From: Ian Brewster
Sent: 27 September 2013 09:55
To: Janice Chapman
Cc: Daniel Vick
Subject: Y/65/13/TC Tall Trees Church Road Yapton BN18 OEJ
Attachments: photo.JPG; ATT00001.txt; photo.JPG

From: Janice Chapman
Sent: 01 October 2013 11:07
To: [REDACTED]
Subject: Y/65/13/TC - Surgery to various trees at Tall Trees, Church Road, Yapton

MAP SHOWING TREES POSITION.

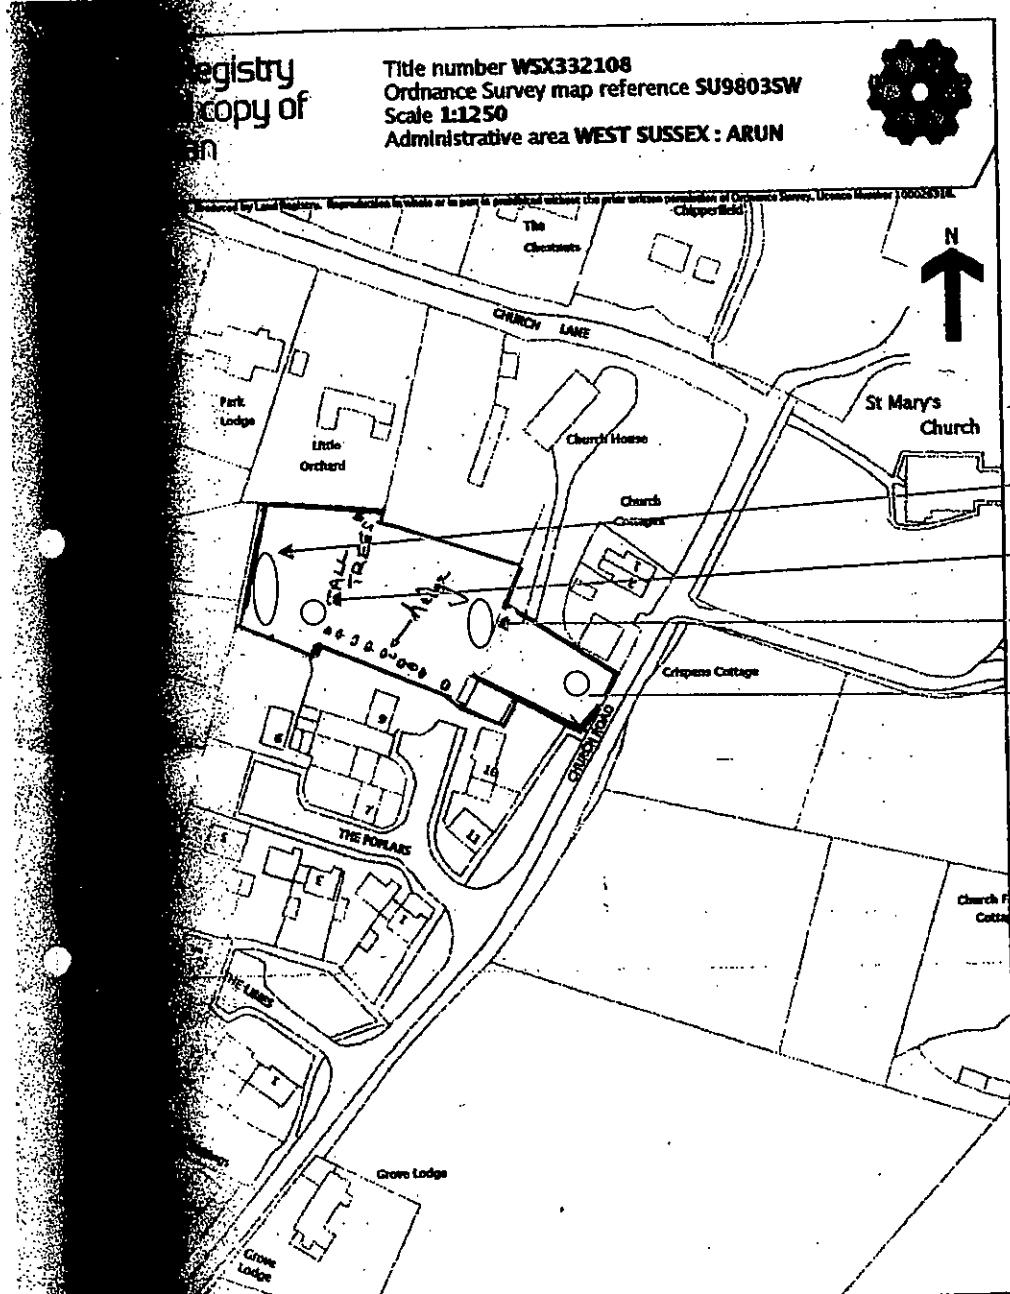
Please find attached two pictures of the Sycamore as viewed from both directions along Church Road which is proposed for removal by the applicant of the above property. I regard this tree as healthy, in good condition and has immediate visual impact of public amenity as viewed from the highway. The Oak is set back behind the rear wall boundary of the adjacent property and is therefore less prominent. The low branches could be reduced away from the hedge. The flint wall located 2.5m from the tree does not show signs of distortion or disturbance. I would therefore recommend that this tree is protected by a Tree Preservation Order.

The Council's Arboriculturist, Mr Brewster has inspected the trees and has raised no objection to the surgery to the Poplar trees, Hawthorn hedge and the felling of the Leylandii tree. However, as the Sycamore tree is in a healthy and good condition and has public visual amenity value he has objected to its removal. He has suggested that the low branches could be reduced away from the hedge.

Hello again,
Hope all's well and thank you for your response yes that sounds fine to crown lift the sycamore and not fell. I will advise my clients and carry out works accordingly.
